INFORMATIONAL COMMENT ONLY
This sign plan has been cursory reviewed with this Site Development Plan but will need to be submitted on its own "Sign Plan" Application via EDARP for official approval. The freestanding sign along Bradley Rd on page 2 of this set may be need to relocated based on the potential Final Plat reconfiguration of the lot.

711 #1057022 BRADLEY AND LEGACY (EL PASO CO)

SIGN LOCATION

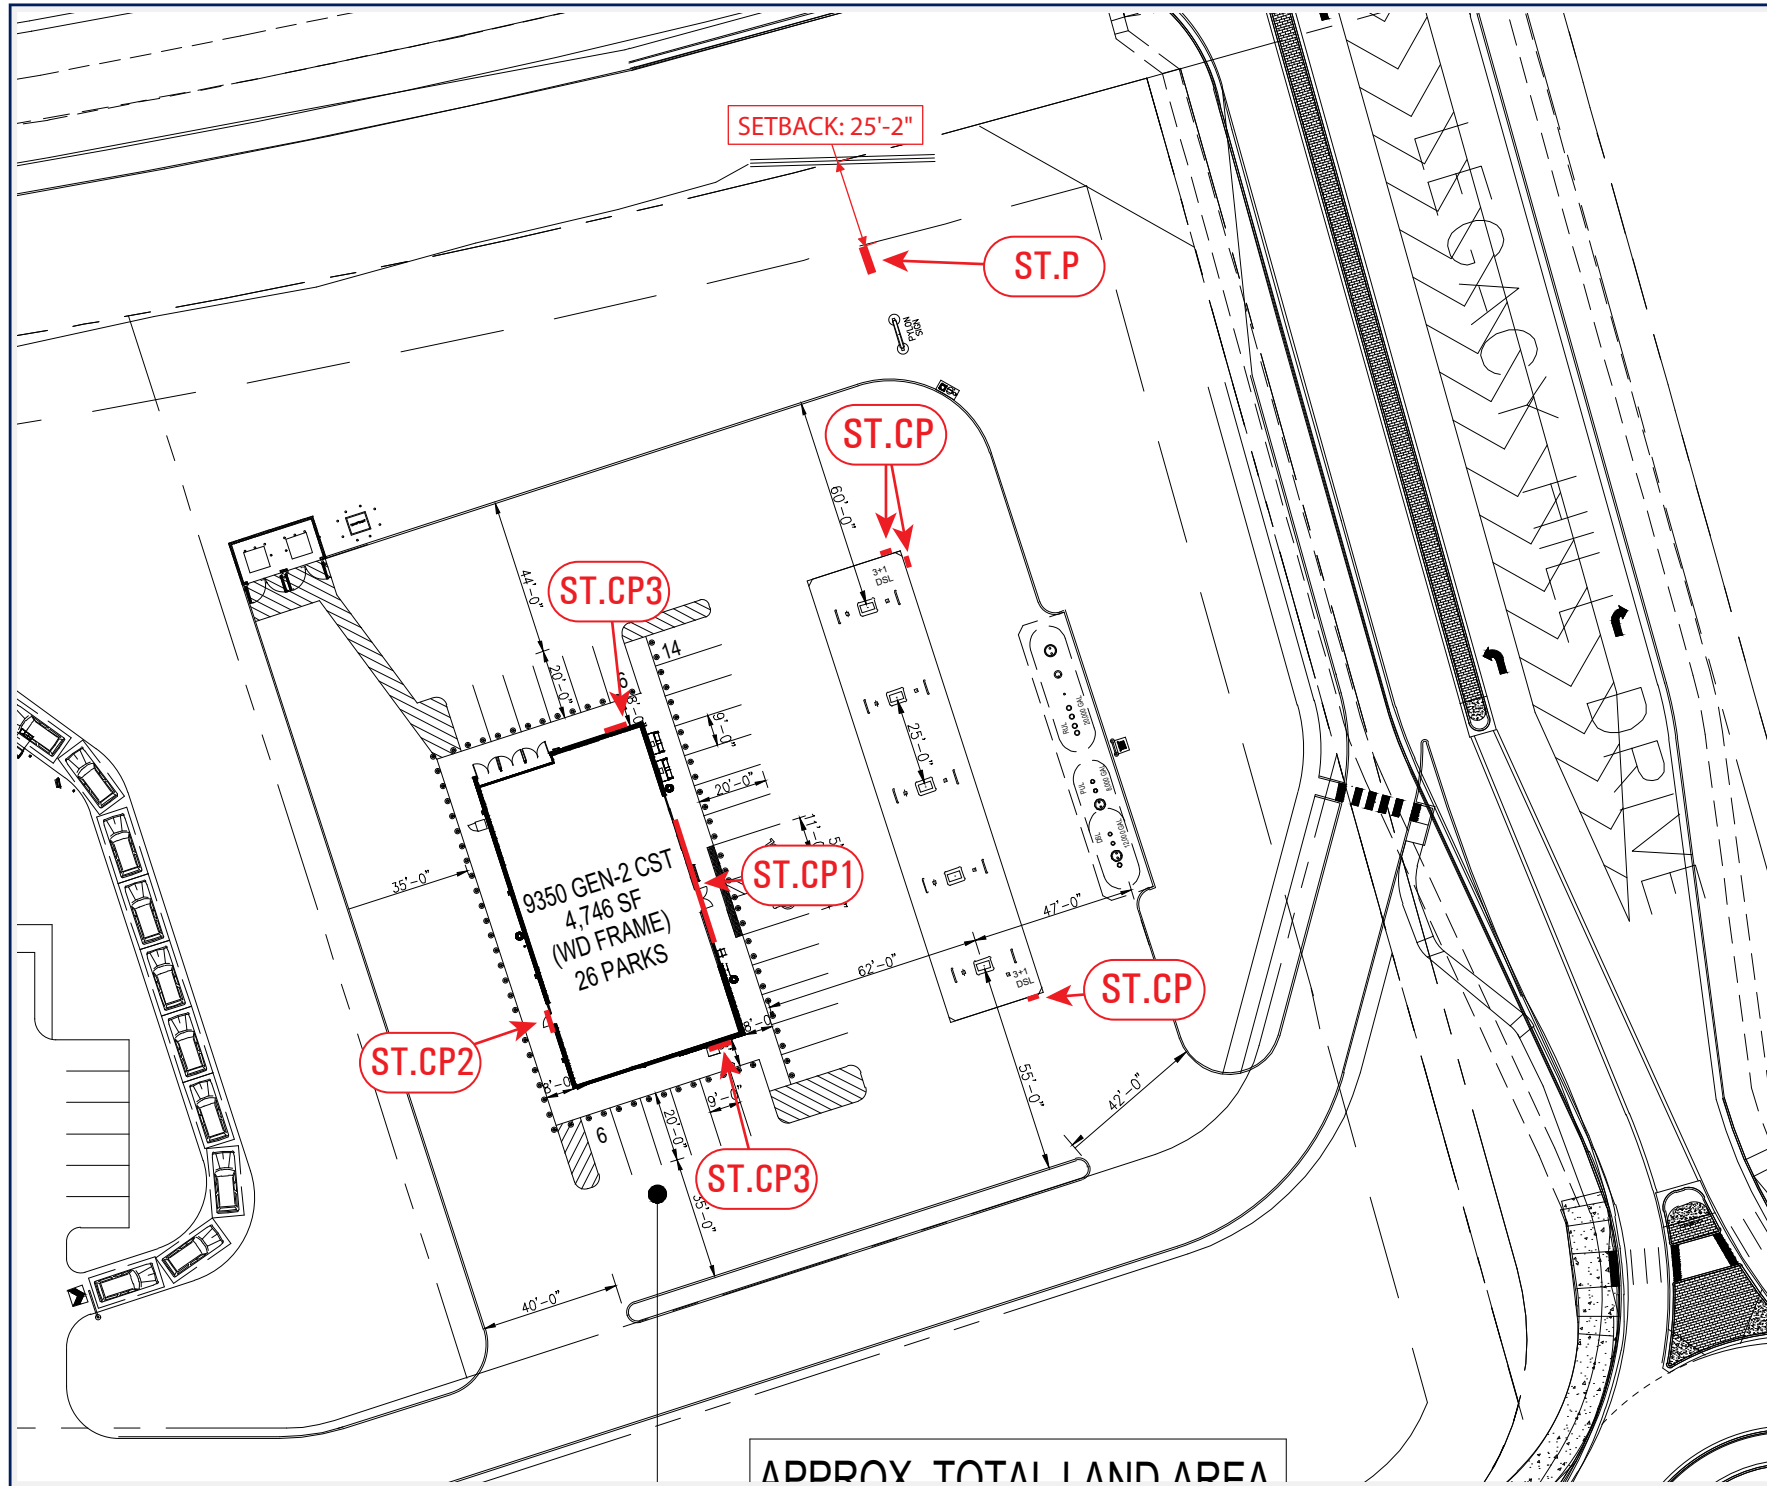
This sign may need to be relocated if the lot changes configuration within the associated Final Plat project currently in review (SF269)
